2.2 Consented Scheme Comparison Proposed Scheme - Second Floor

Bay F  
Proposed Typical Bay Study - Conference Centre

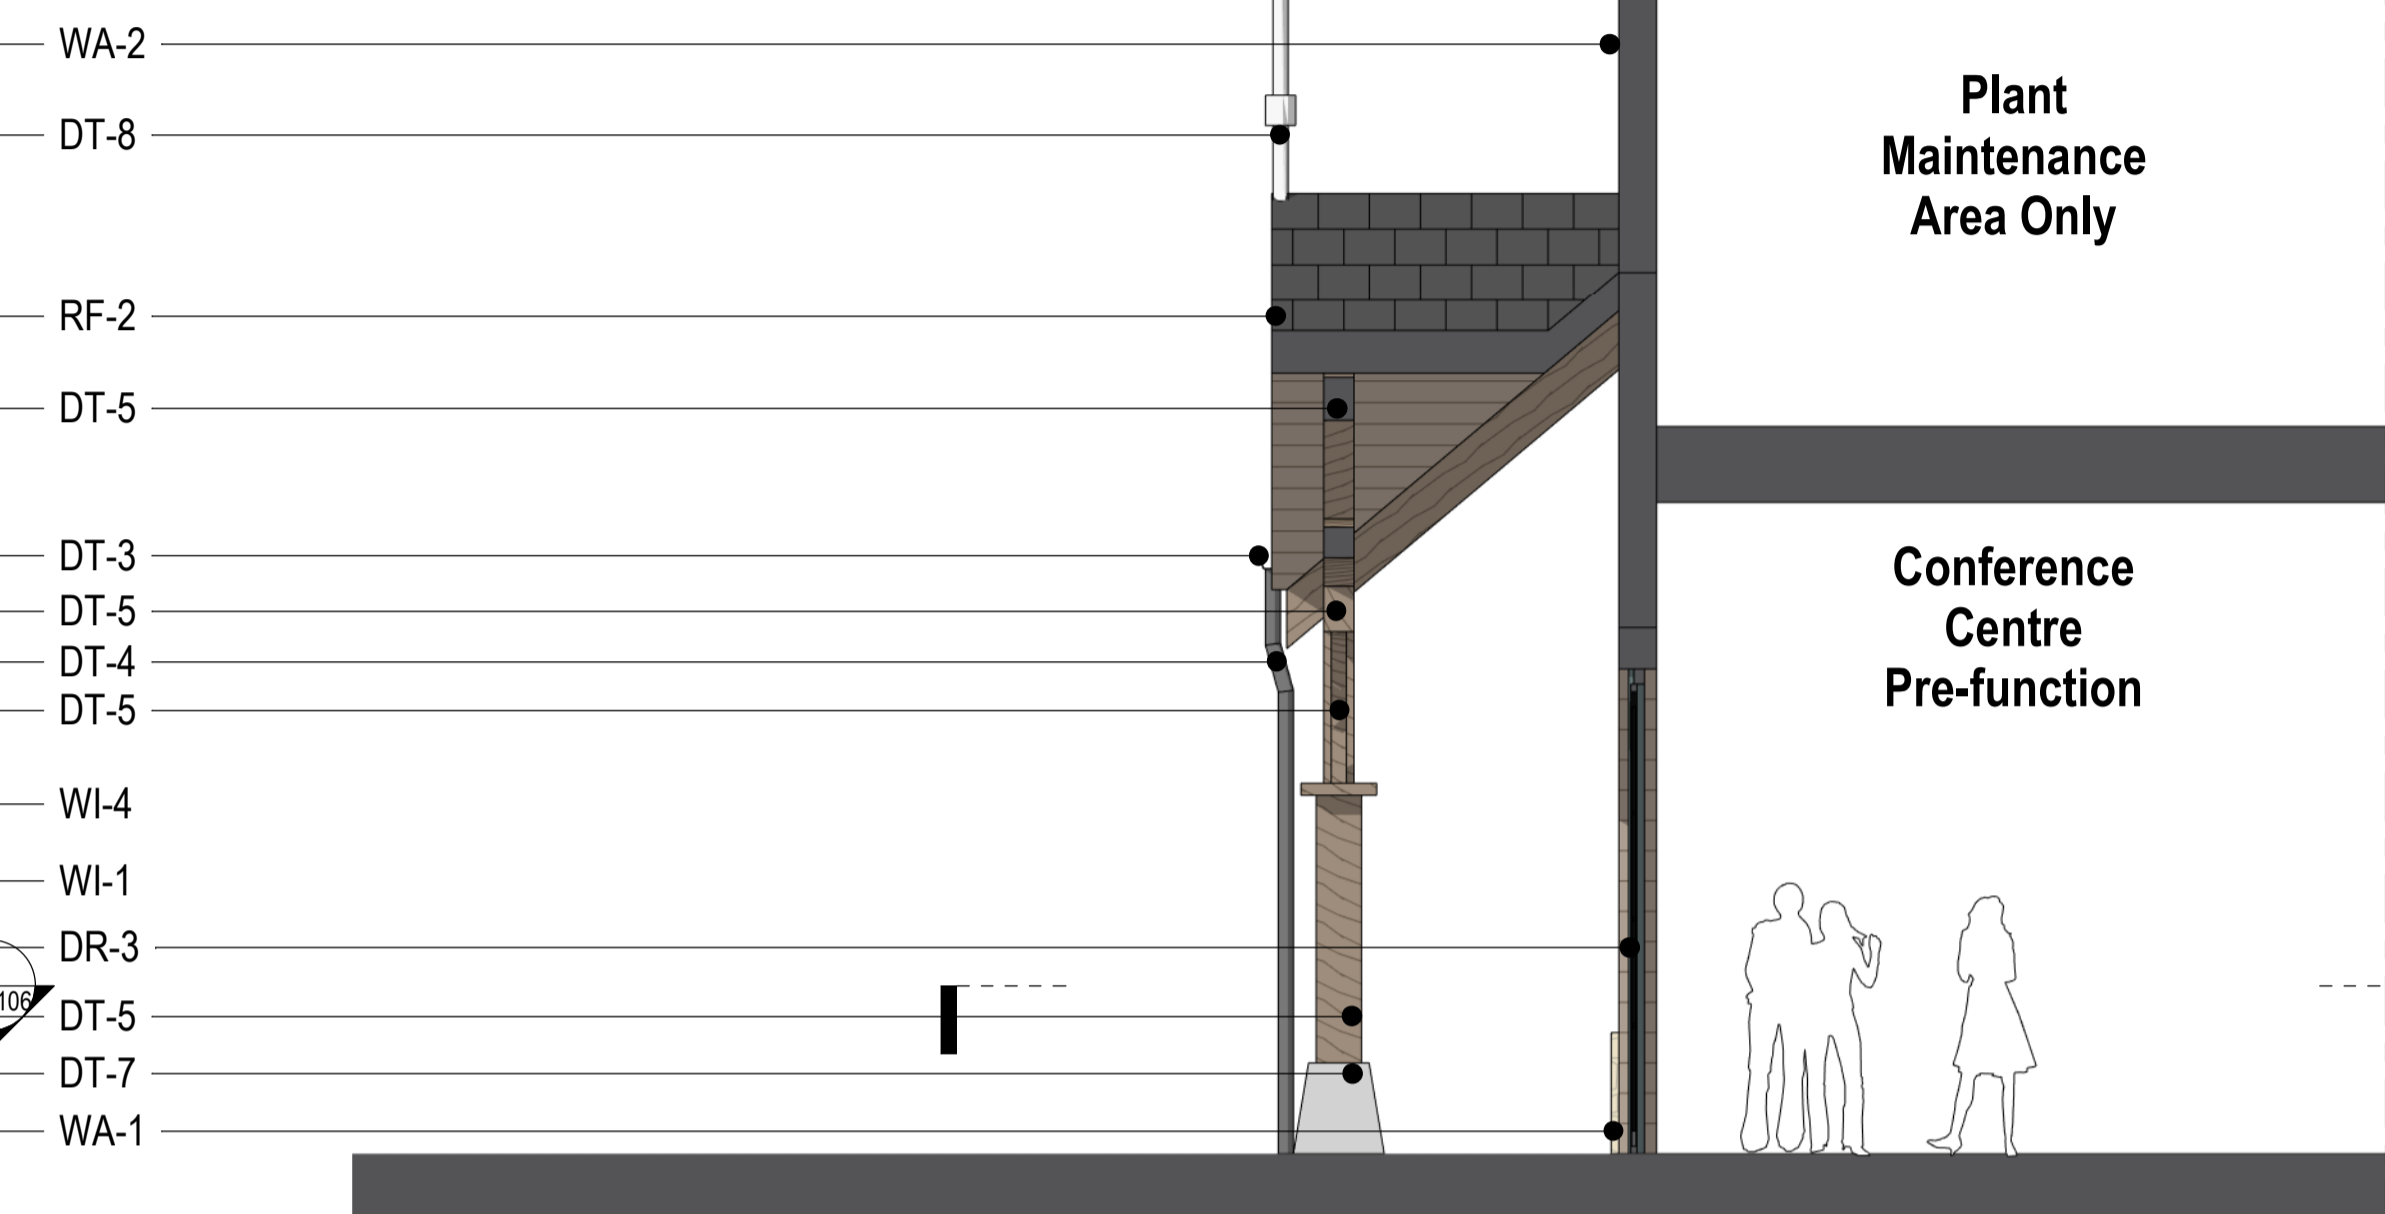
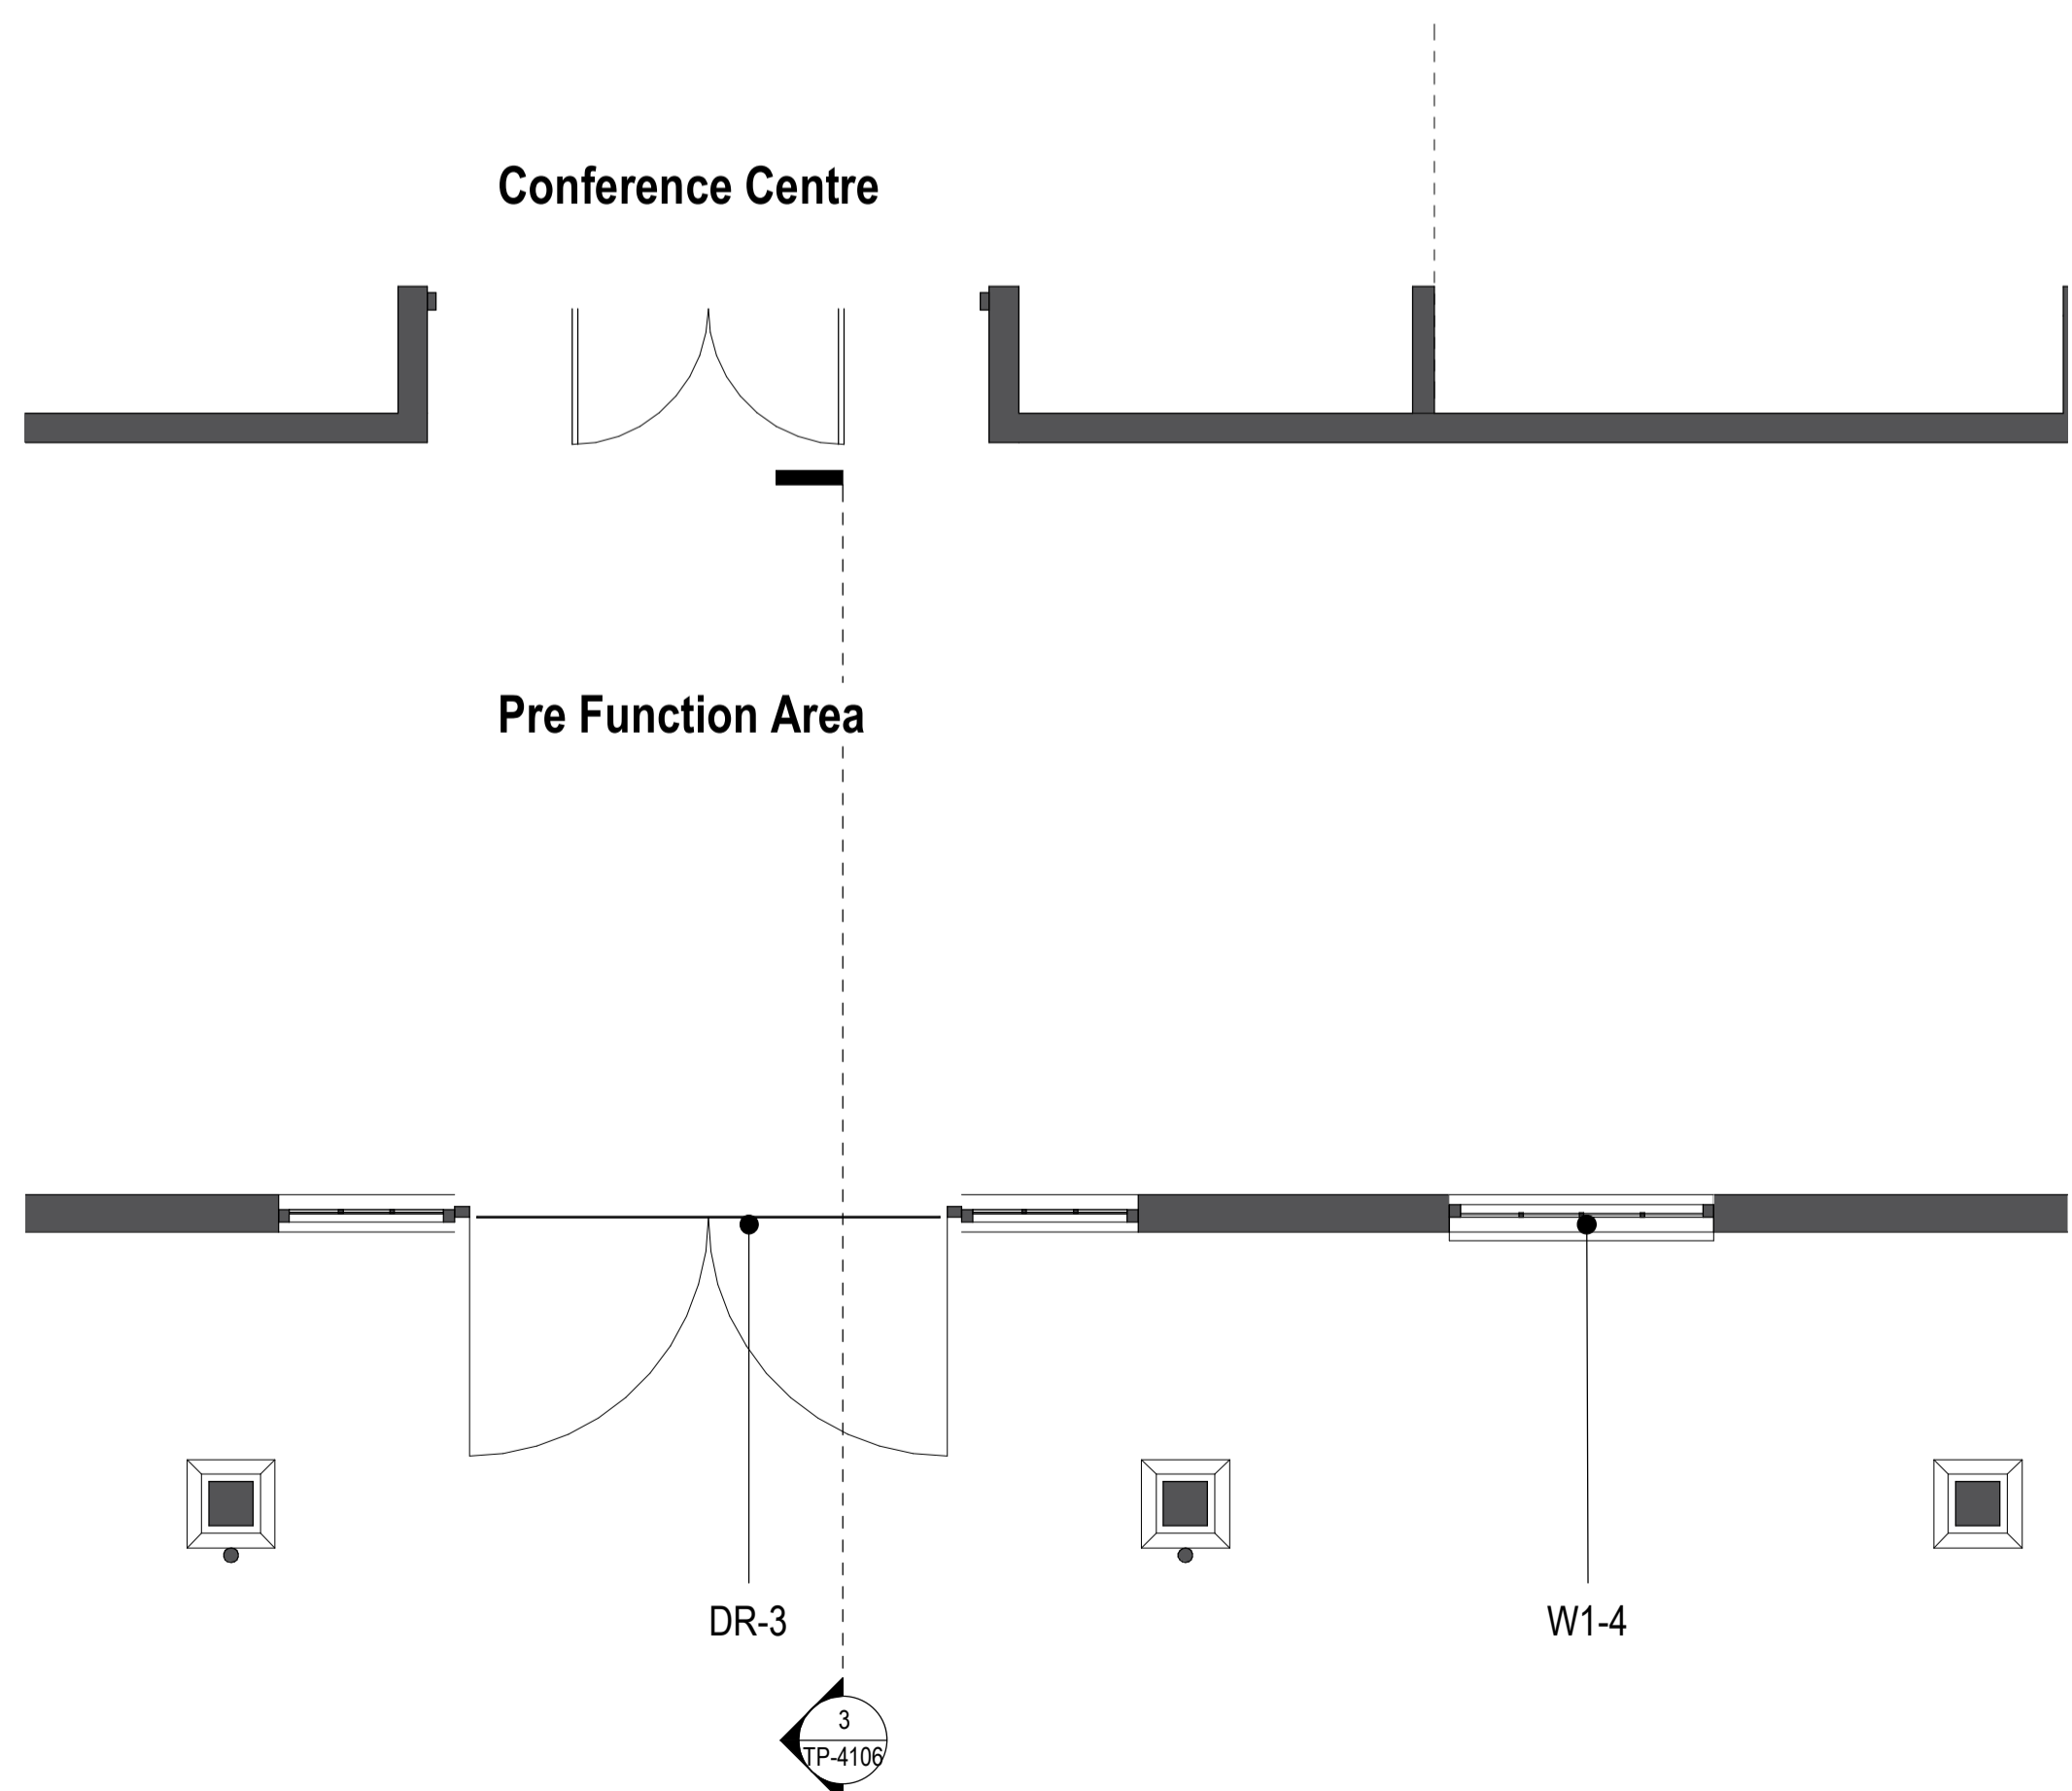
- 1. Re-configuration of the conference centre massing, facade design and internal layout. The overall reduction in the area of the FEC, Conference Centre and main BoH is approximately 1% from consented scheme.
